Application for Planning Permission for Works or Extension to a Dwelling

Development: Proposed rear porch.
Location: 3 New Thatched Cottages Climping Street Climping BN17 5RJ

Elevations -
Proposed

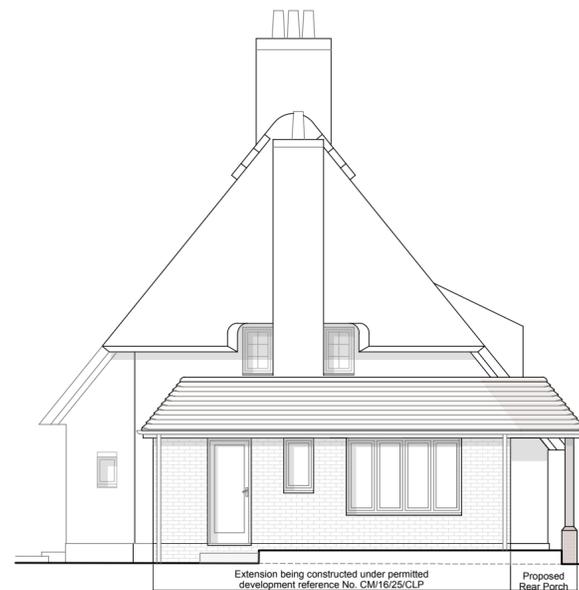
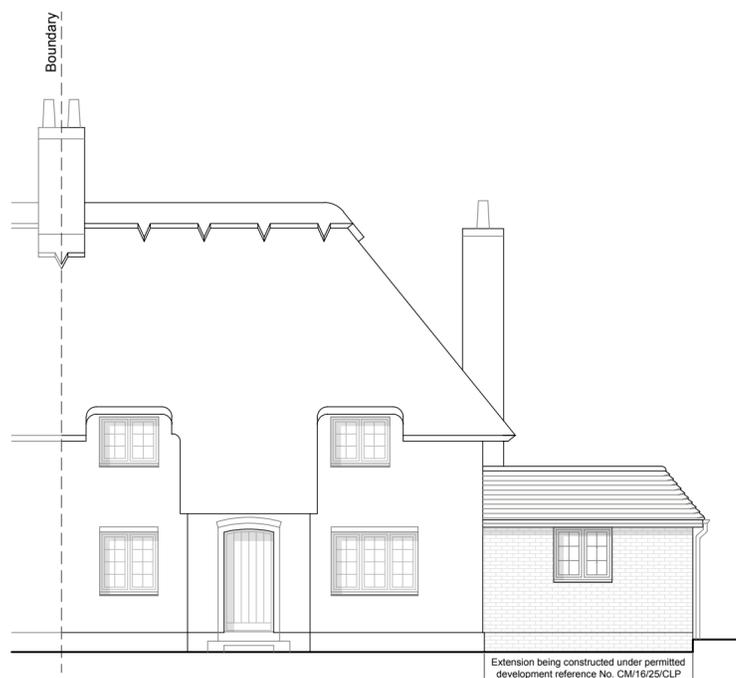
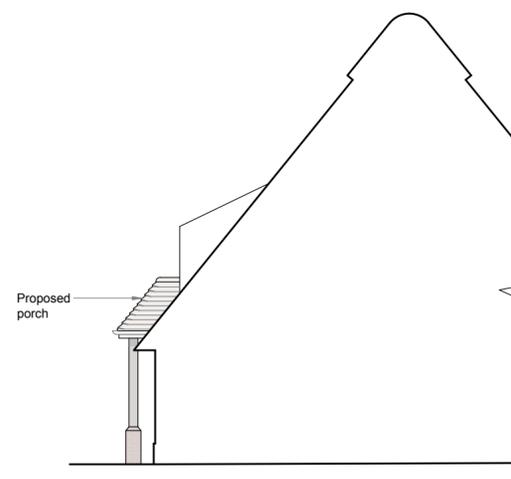
Elevations

Please submit electronic plans in pdf format clearly labelled existing and proposed other side elevations at a scale of 1:50 or 1:100. Further details can be found in the Validation Requirements List.
